DECISION DELEGATED TO HEAD OF PLANNING

Application No: H13-0507-24 **Applicant:** BLM Builders Ltd
Proposal: Residential Development - 2 Dwellings - Outline Approval H13-0651-20
Location: Rear Of War Memorial Seas End Road Moulton Seas End
Terminal Date: 5th November 2024

J185-PL 18

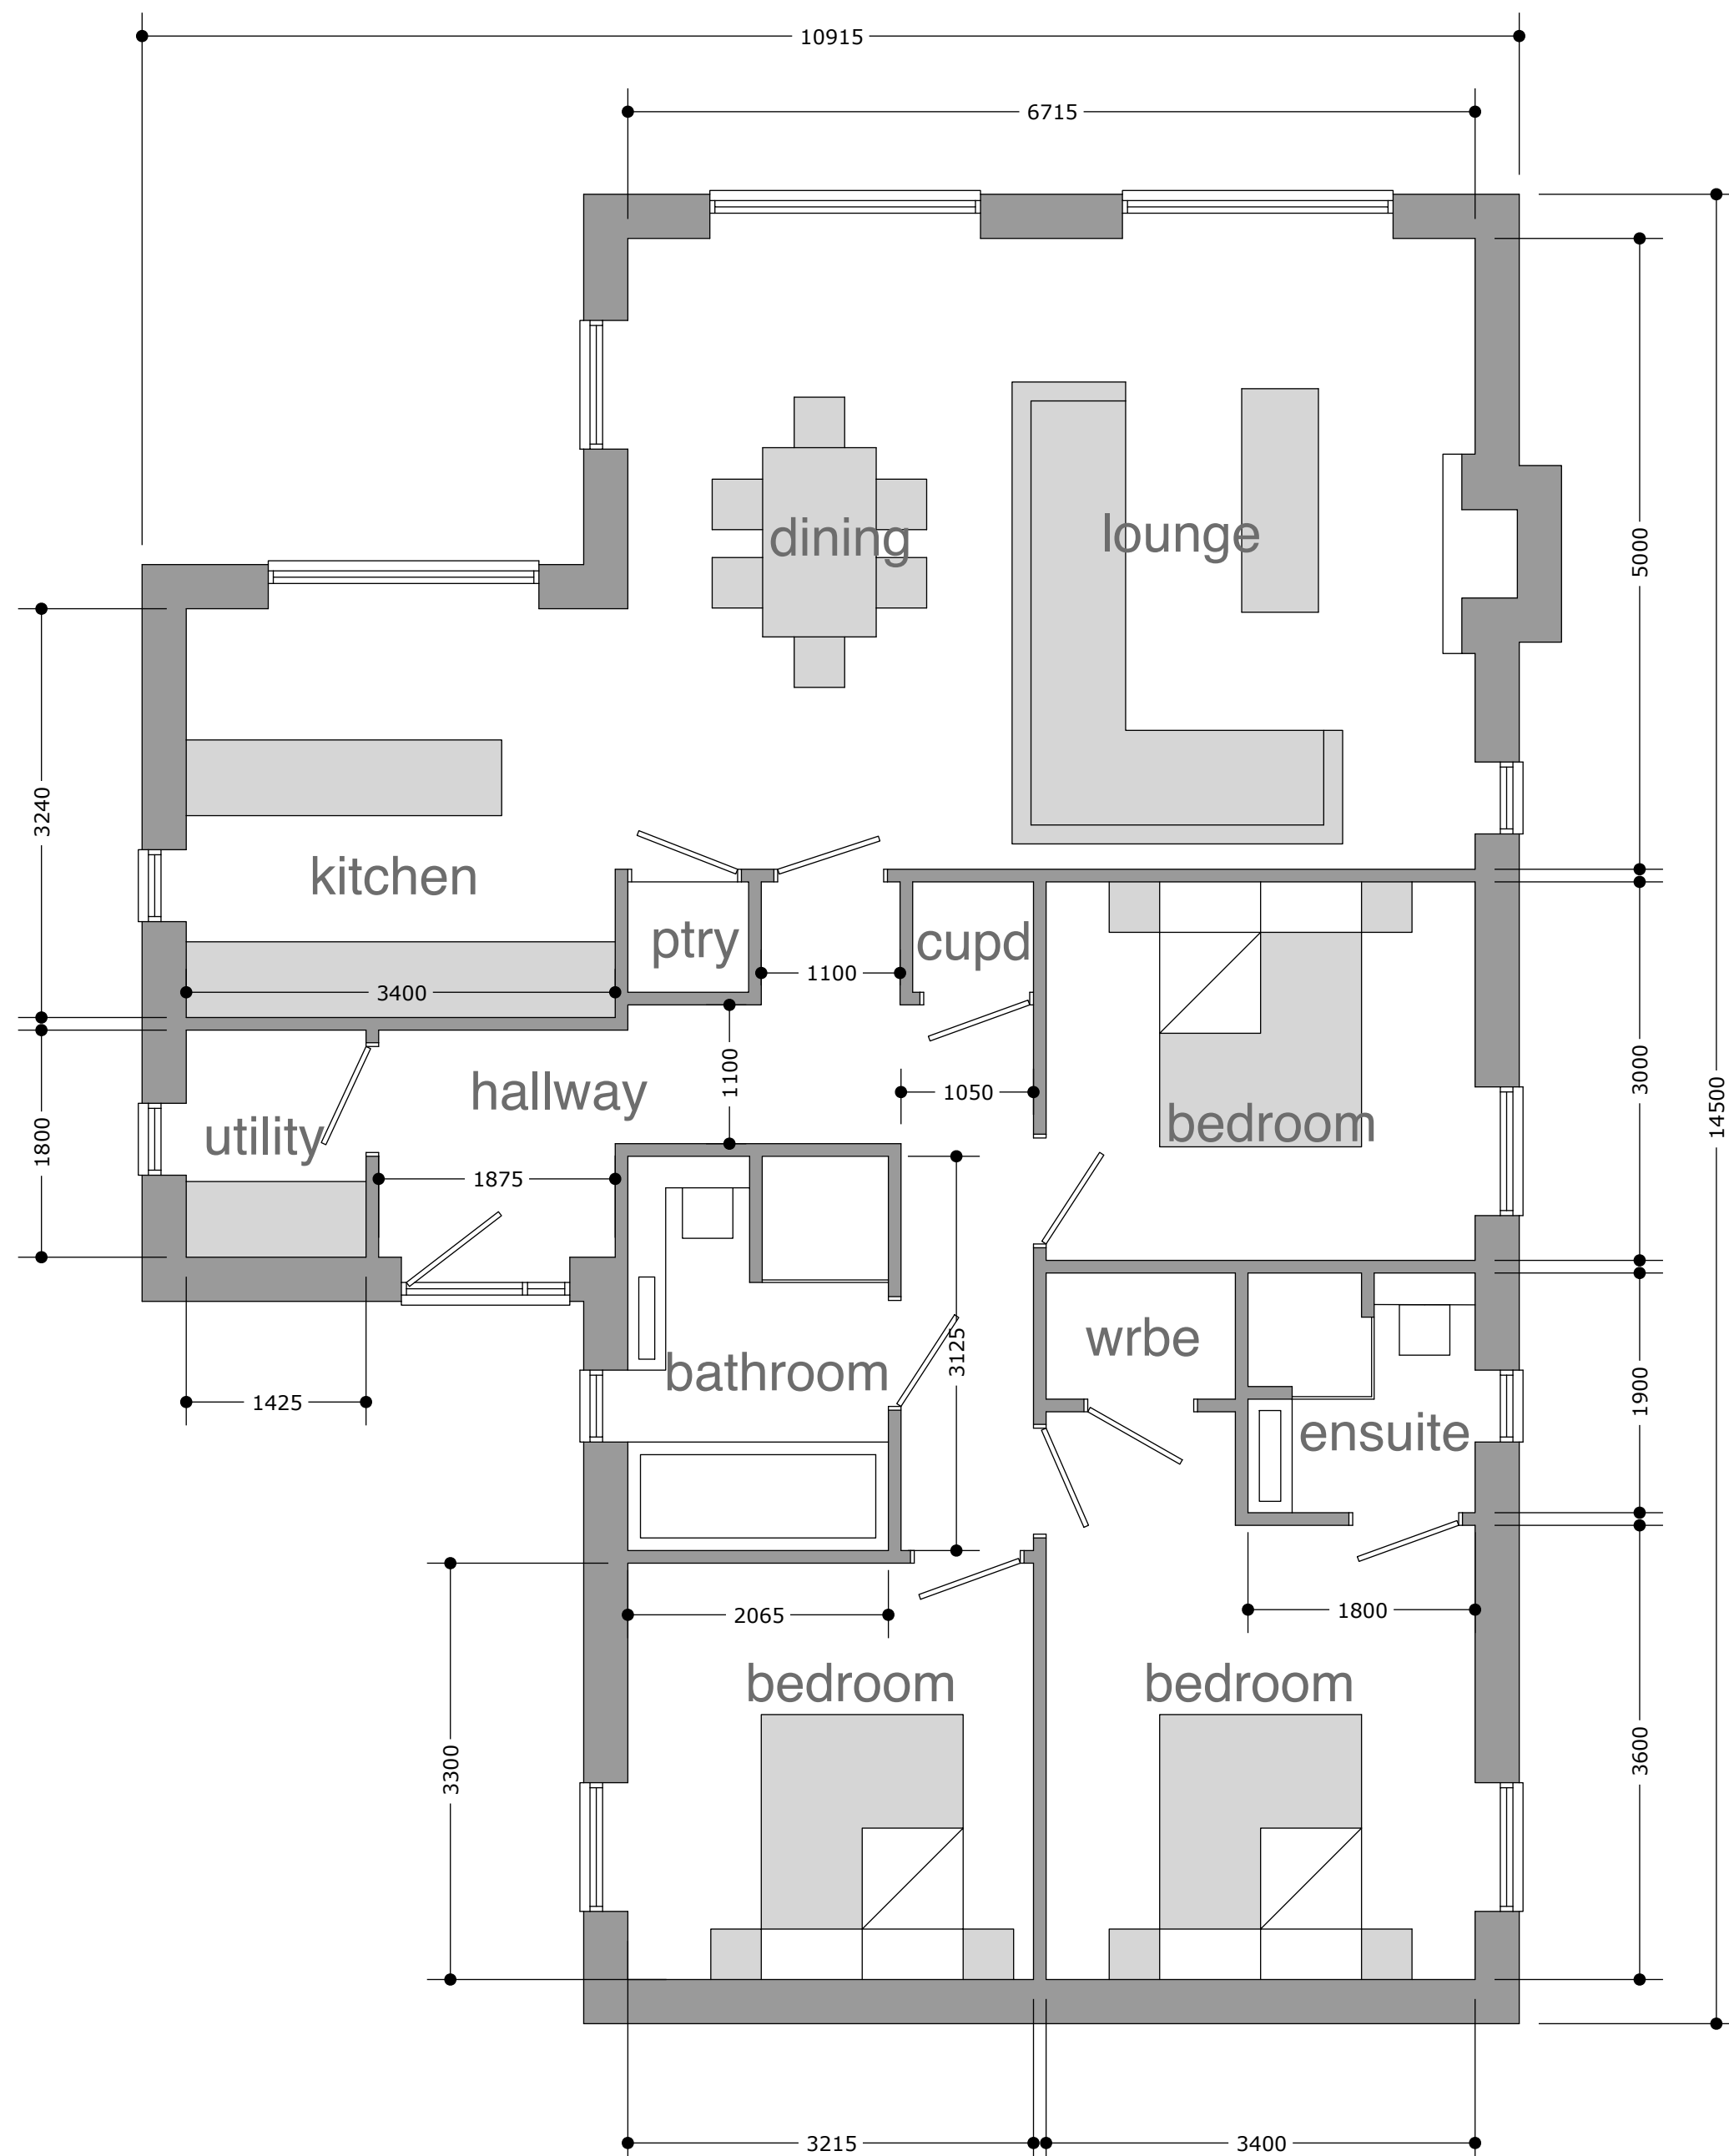
The dwellings would measure 14.5m by 11.2m, and approximately 4.3m up to their roof ridgelines. A chimney breast is proposed on each dwelling, and this would measure 4.9m in height.

The proposed dwellings feature floor length windows, which would give the dwellings a more contemporary appearance than some of the neighbouring properties. The dwellings would however be located towards the rear of the site, which would reduce their impact on the street scene. Nearby dwellings feature a mixture of red and brown brickwork and rendered facades. There is a range of house types within the area and there is therefore no strict uniformity. The proposed materials for the bungalows include 'red orange multi bricks' and terracotta pantiles. It is therefore considered to be appropriate to secure further details of the proposed materials via a condition. The scale and positioning of the bungalows is acceptable given the divergence of the surrounding settlement pattern.
